**New Maitland Hospital (Stage 2), Metford Road, Metford (SSI-9775)  
Notice of Exhibition**

## **TAB A – Detailed Comments on State Significant Application SSI-9775**

**Figure 43 Staff and visitor parking arrangement**

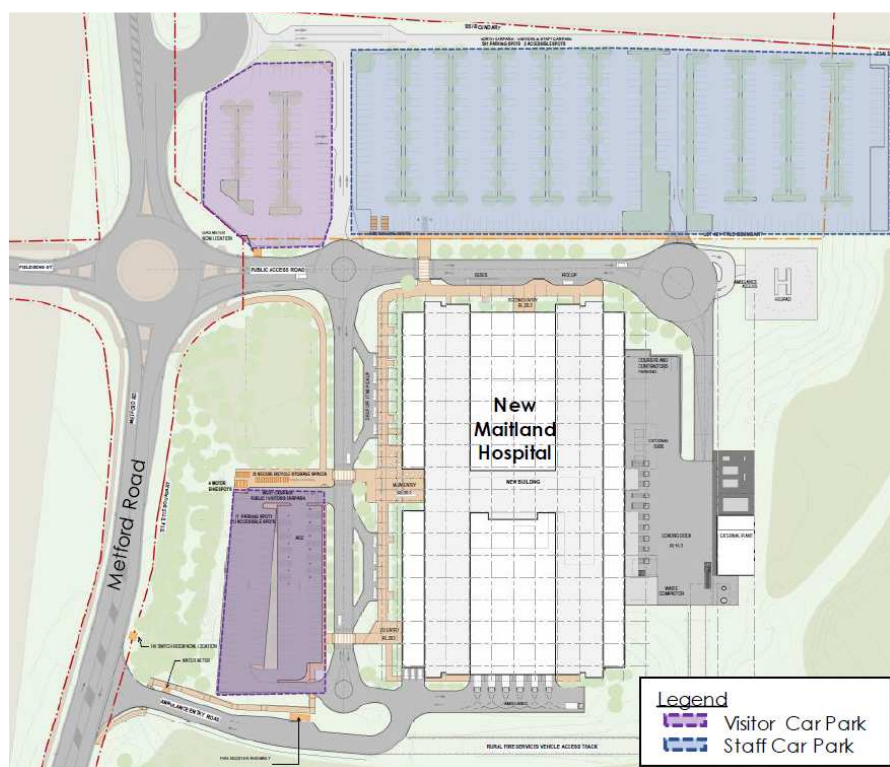
The Transport Assessment provided in Appendix H of the EIS proposed 1 bus stop bay based on recommendations outlined in the *State Transit Bus Infrastructure Guide (BI Guide)*. These recommendations are based on a 20 – 30 second dwell time; however buses servicing a hospital development would typically have increased dwell times. As such, a more conservative approach to the bus bay capacity is recommended.

Further assessment of the bus bay requirements based on a more conservative assumption regarding dwell times should be undertaken in consultation with TfNSW. A sufficient allocation of space in the bus bay should be reserved – with a preferred outcome of at least two buses to be accommodated at any given time.
